Subject: FW: LU/370/19/HH

Having gone through the plans in depth there is a large amount that needs doing. Please see below for all the changes that need to be made in order for the plans to align.

Roof Detail Scale 1:100

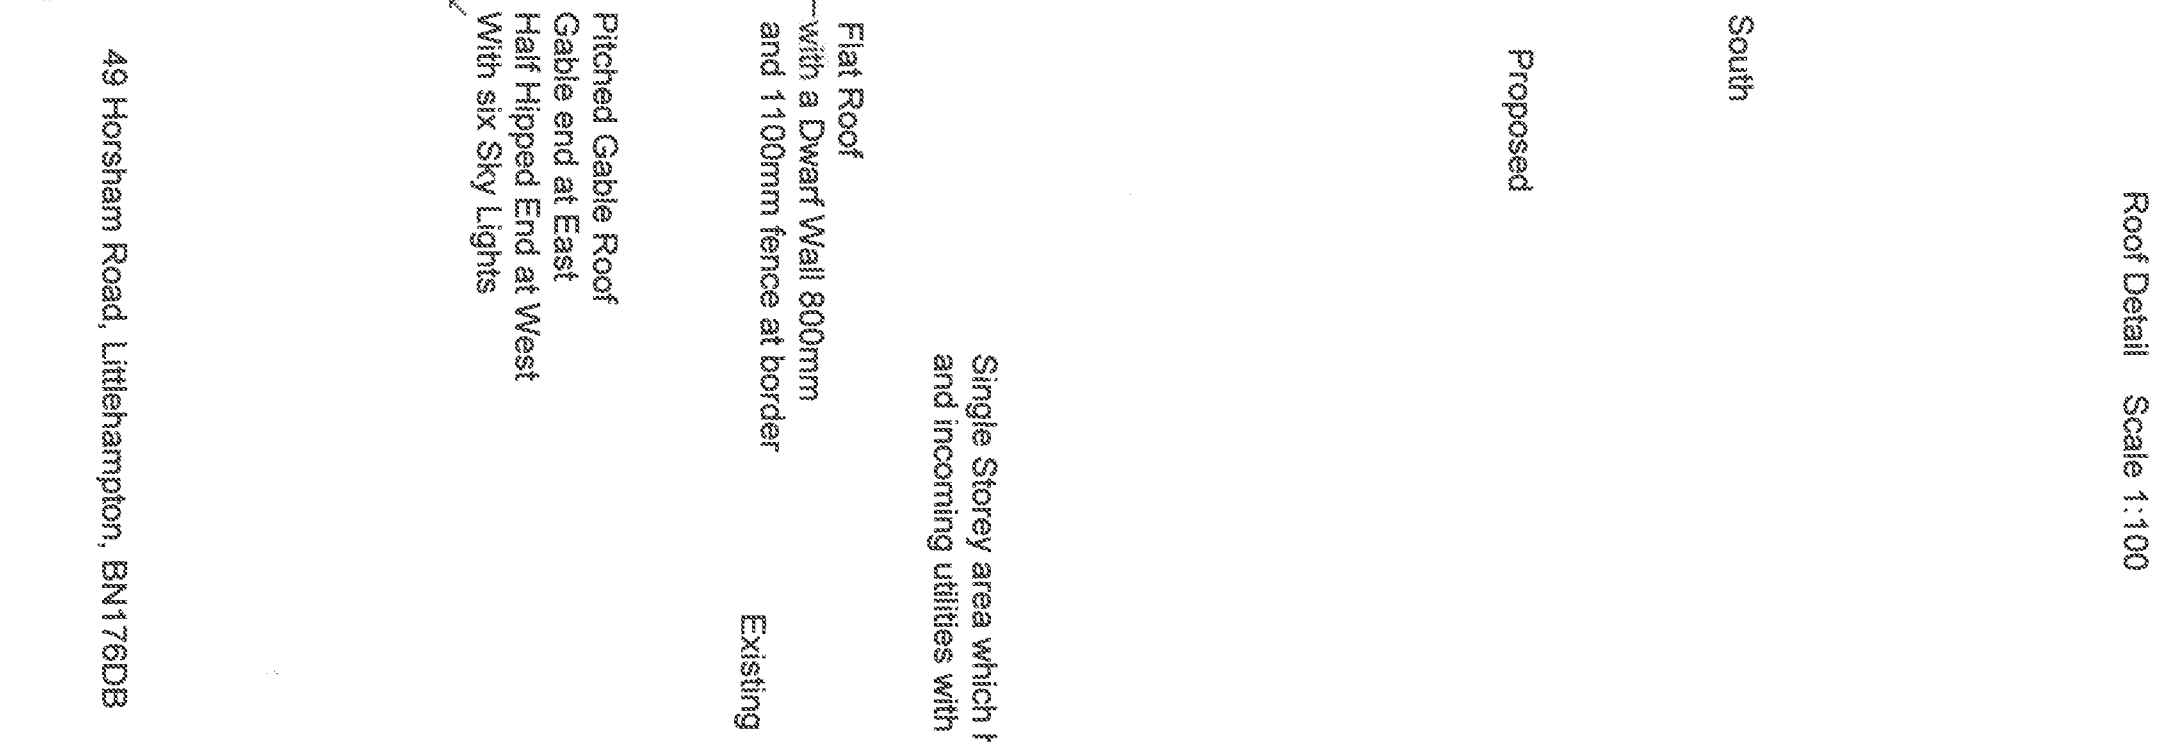
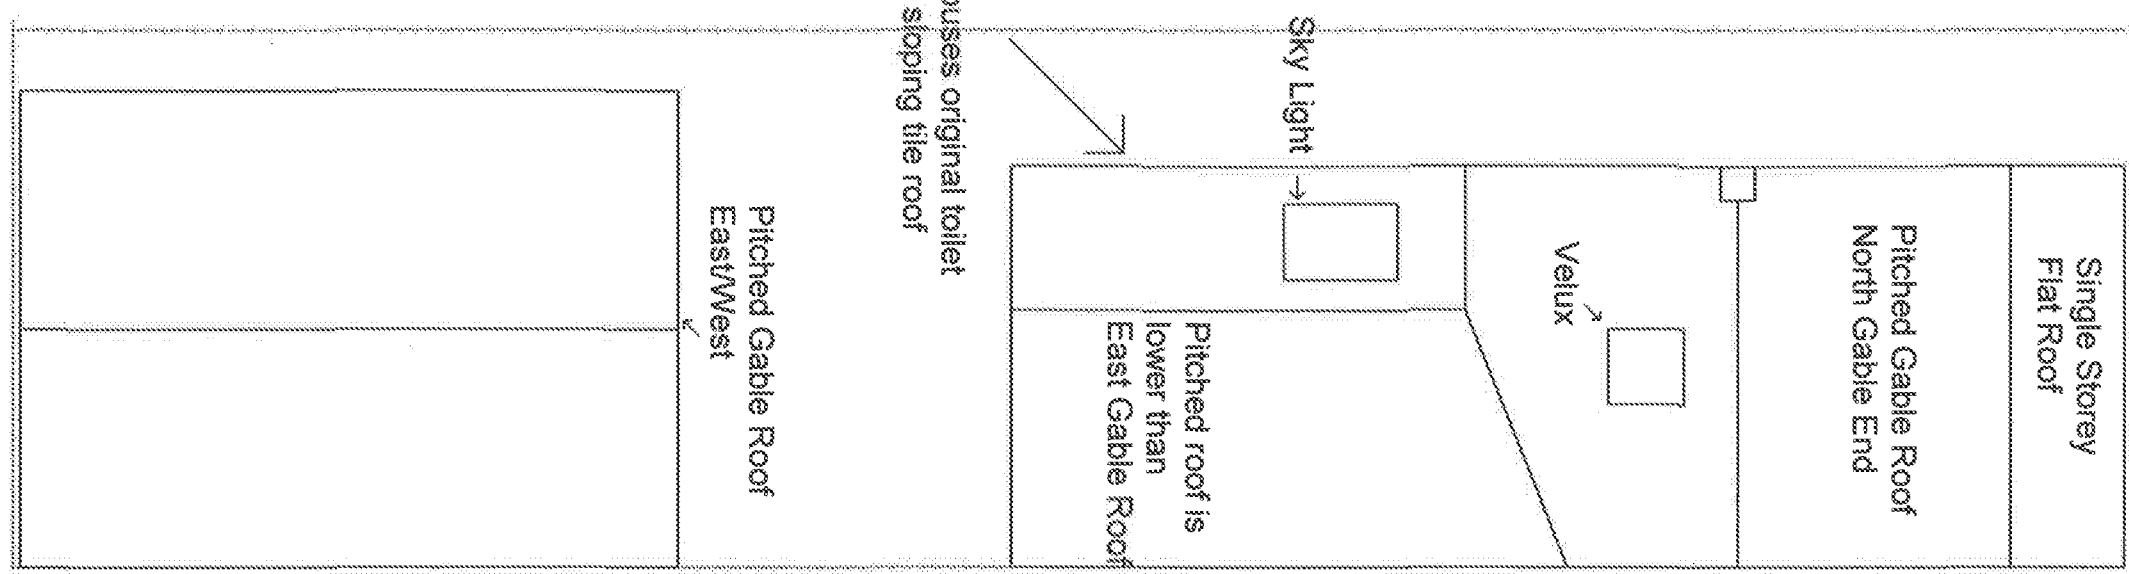
- The pitch roof needs to be shown above the shop/flat to be east/west as the gable ends are not to the front and rear currently.
- In the pitch there needs to have the existing roof light illustrated.
- The existing roof to the south needs to be shown to have a lower pitch height than that of the one visible from the street scene.
- The roof slopes need to be indicated.
